WEST SUSSEX COUNTY COUNCIL CONSULTATION

TO:	Arun District Council FAO: Simon Davis
FROM:	WSCC - Highways Authority
DATE:	8 March 2022
LOCATION:	Bonhams Field Main Road Yapton BN18 0DX
SUBJECT:	Y/186/21/PL Erection of 32 No dwellings with associated works including access, landscaping and parking. This application may affect the setting of a listed buildings, may affect the Main Road/Church Road Conservation Area. This application is in CIL Zone 2 and is CIL Liable as new dwellings.
DATE OF SITE VISIT:	n/a
RECOMMENDATION:	No Objection
S106 CONTRIBUTION TOTAL:	s106 or UU for £1,500 travel plan statement fee

KEY	
	Phase 2 Site Boundary
	Proposed Trees
	Bicycle Store
	Phase 1 Site Boundary
	Consented Scheme
	M4(2) Compliant Plots

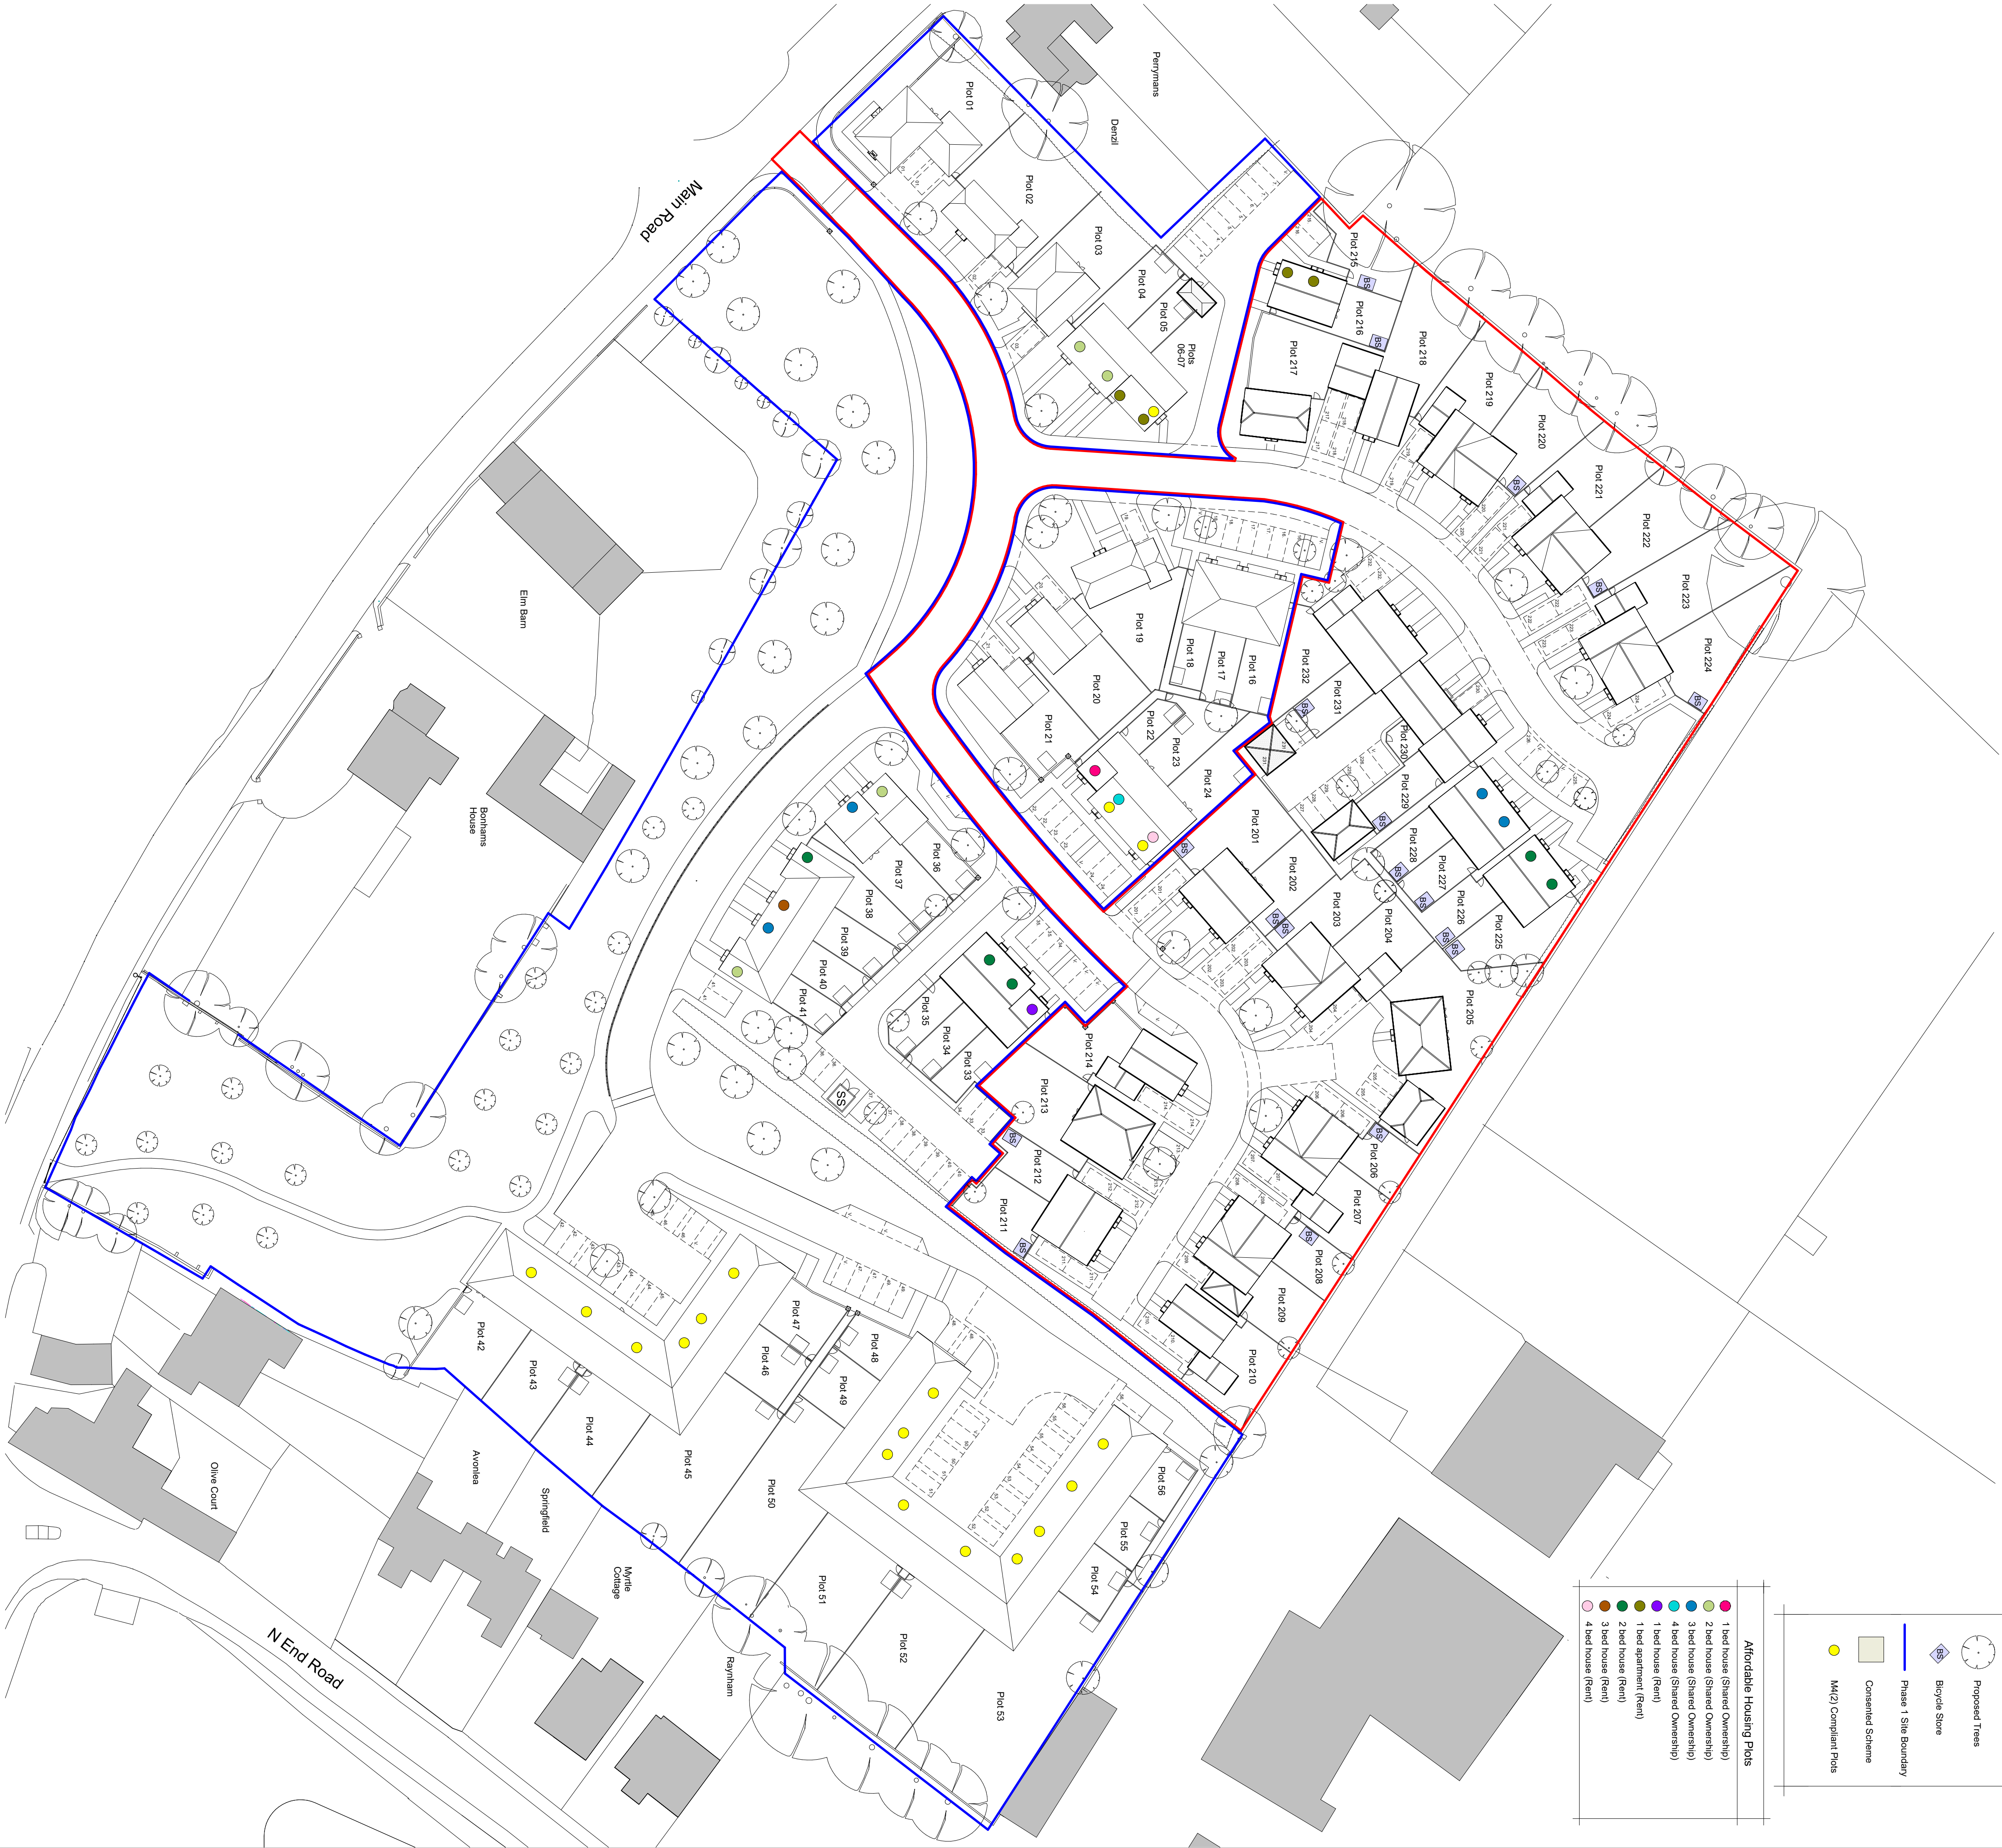
Changes have been made to the turning head at the end of the first off-shoot road. This has been created so it abuts the redline boundary. Refuse vehicle tracking and layout review (104367-TR-SK001 Rev F) show a refuse vehicle can use this turning head safely.

Details of materials, and street furniture specs are not approved at this stage and will be checked at detail design stage forming part of any s38 agreement. It is not clear what surface materials will be used but generally contrasting materials would be used between roads and footways.

It is noticed the layout of the footway where it links to the private farm track may need to be widened and re-designed to connect with the turning head. The link entrance does not seem very wide and may need re-designing in this area to avoid walking/cycling over the footpath of plot 225.

The turning head also has a footpath which does not link into anything. This could be used for the planting of more trees or vegetation to soften the area and introduce some urban greening to the site.

WSCC would ask the applicant to provide an updated plan showing the location of the 'safeguarded area' in relation to the new turning head layout.
